From: Nolan, Chris <Chris.Nolan@lancashire.gov.uk>
Sent: 31 January 2018 13:09
To: Robert Major; planning
Cc: LHS Customer Service
Subject: D3.2018.0028 - Moorgill 4 Wiswell Lane Whalley Lancashire BB7 9AF

Planning Application No: 3/2018/0028
Grid Ref: 373636 436729

Proposal: Proposed alterations and extension to existing property and erection of a detached garage. Erection of two four-bed detached dwellings with detached double garages.
Location: Moorgill 4 Wiswell Lane Whalley Lancashire BB7 9AF

PROPOSED PLANS AND ELEVATIONS FOR DOUBLE GARAGES					
Site: 4A Wiswell Lane Whalley					
Client: Mr Atherton					
Date: 10.01.18		Scale: 1:100 @ A2			
Project No: AT/09 Dwg 05			Drawn: AxK		
Amendments:

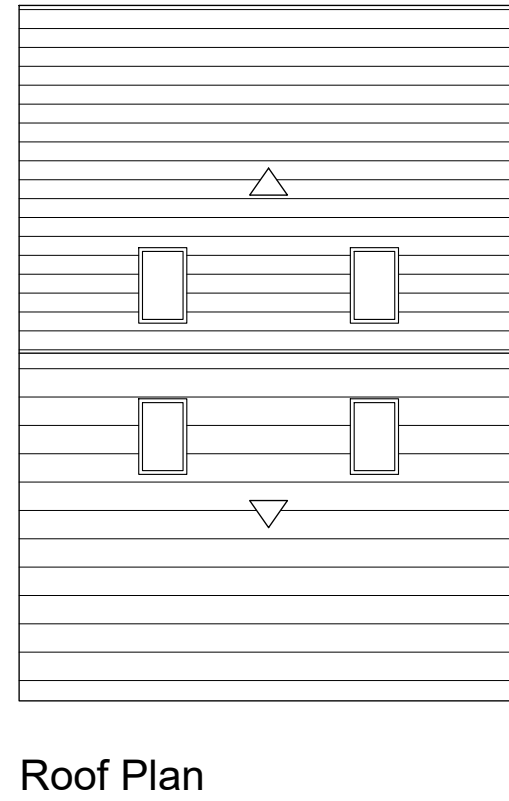
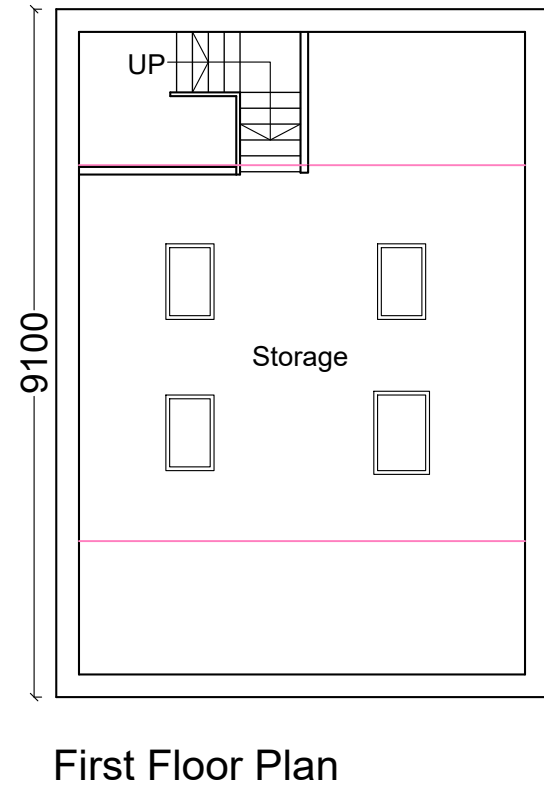
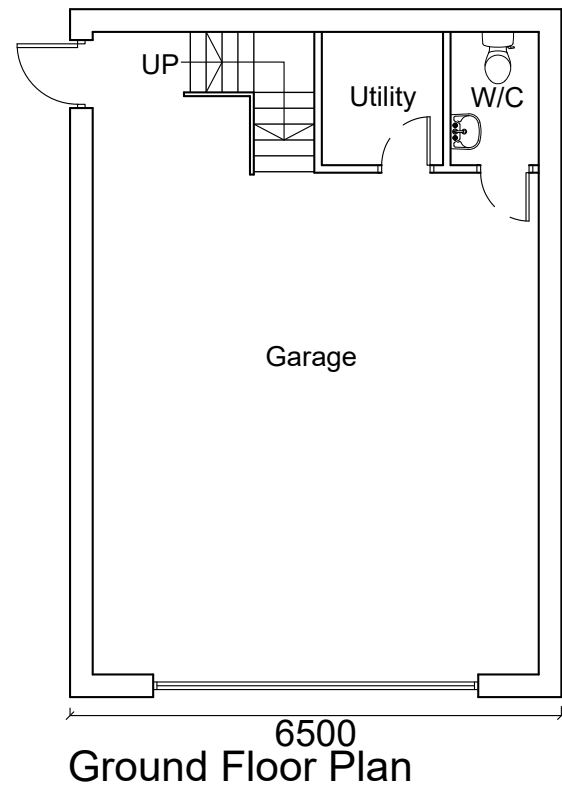
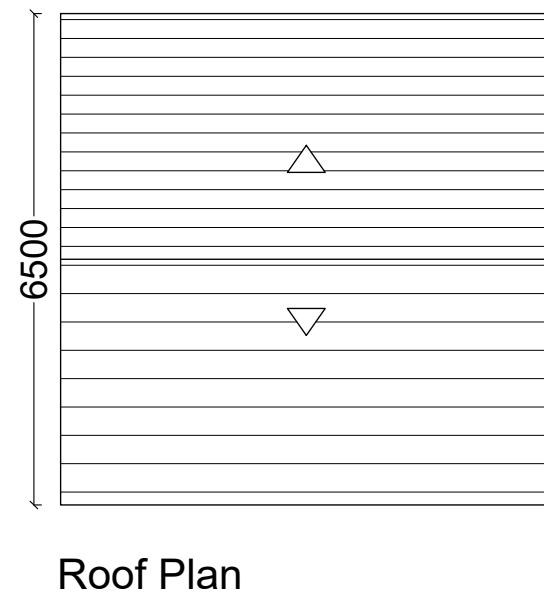
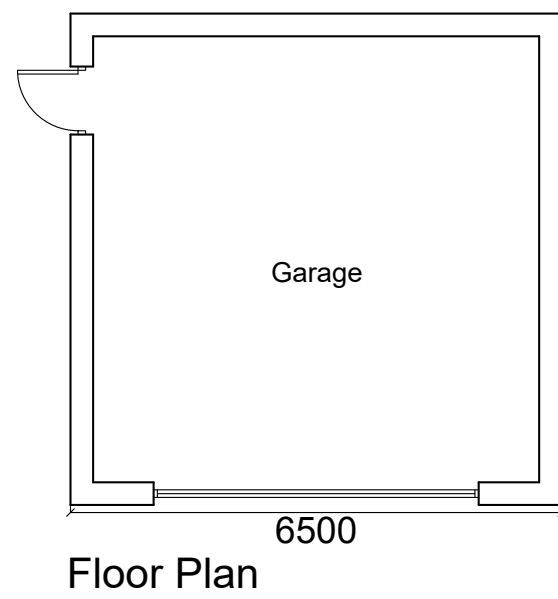
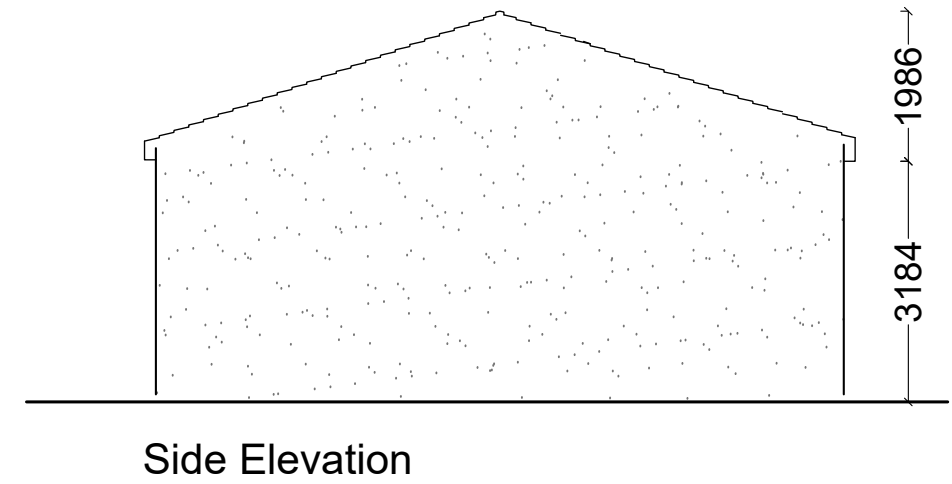
With regard to the above planning application to build an extension to No.4 Wiswell Lane Whalley and to build two new dwellings, along with three double garages to be associated with each home. My first observation is that the new dwellings, as indicated on the plans are 5 bedroom units with a potential of having 6 bedrooms. For planning purposes the declared attic study would need to be considered as a potential bedroom because of its position within the house even if the design is for study use. That said the parking requirement for a 6 bedroom home is the same as that for a 4 bedroom unit. The site plan does indicate that each home will have sufficient parking for three or more cars and therefore this criteria has been fulfilled.

2. All garage facilities shall have facility of an electrical supply suitable for charging an electric motor vehicle. Reason: - in order to promote sustainable transport as a travel option and reduce thereby carbon emissions.
3. No part of the development hereby approved shall commence until a scheme for the construction of the site access and the off-site works of highway improvement has been submitted to, and approved by, the Local Planning Authority in consultation with the Highway Authority. Reason: In order to satisfy the Local Planning Authority and Highway Authority that the final details of the highway scheme/works are acceptable before work commences on site.
